KITTITAS COUNTY
DEPARTMENT OF PUBLIC WORKS

MEMORANDUM

TO: Mackenzie Moynihan, Community Development Services
FROM: Randy Carbary, Planner II
DATE: February 26, 2008
SUBJECT: Finley Plat

FINLEY PLAT
PORTION OF THE NE 1/4, SEC. 29, T.17N., R.20E., W.1E.
KITKITAS COUNTY, WASHINGTON

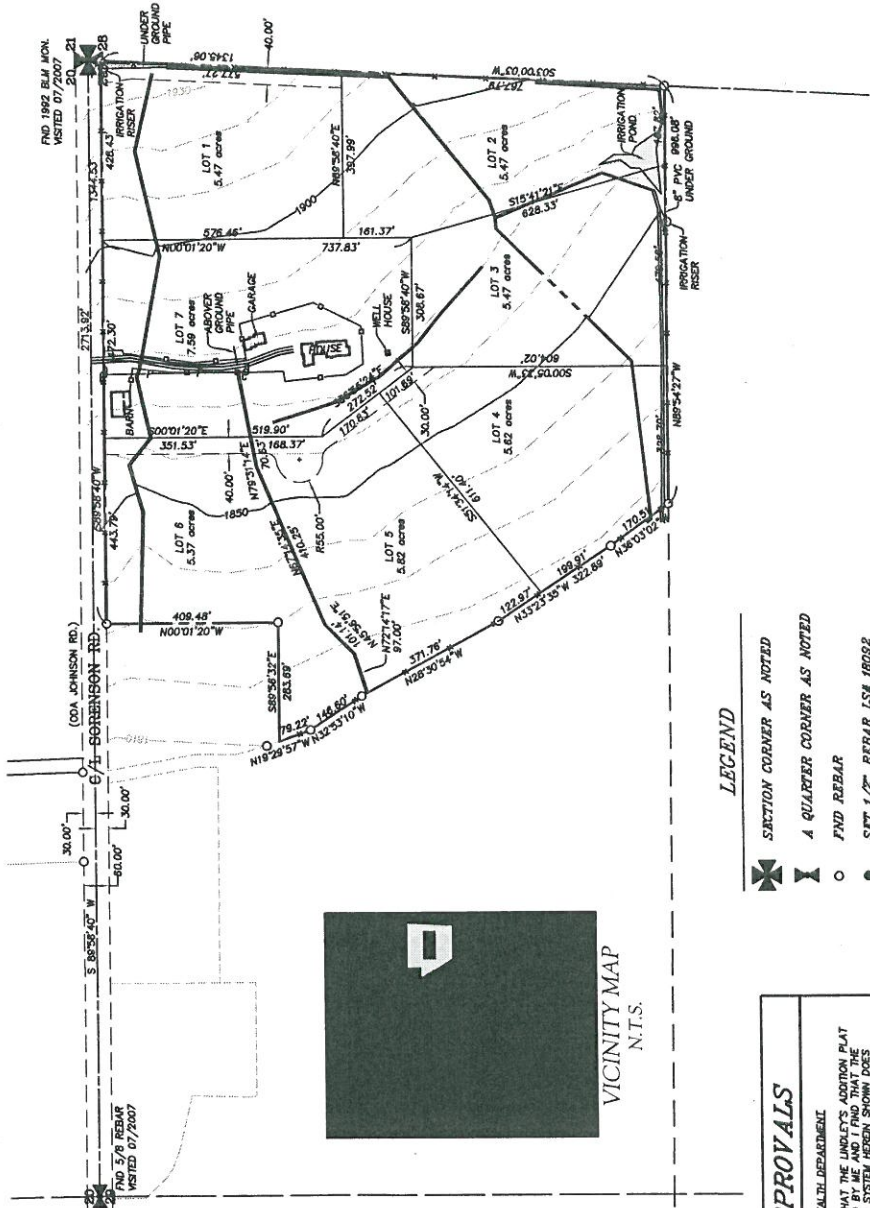
1. Access to Lot 2: The proposed access to lot 2 does not meet the 100' minimum access spacing required by current Kittitas County Road Standards. The application shall be revised to reflect an access location for lot 2 which meets or exceeds current Kittitas County Road Standards.
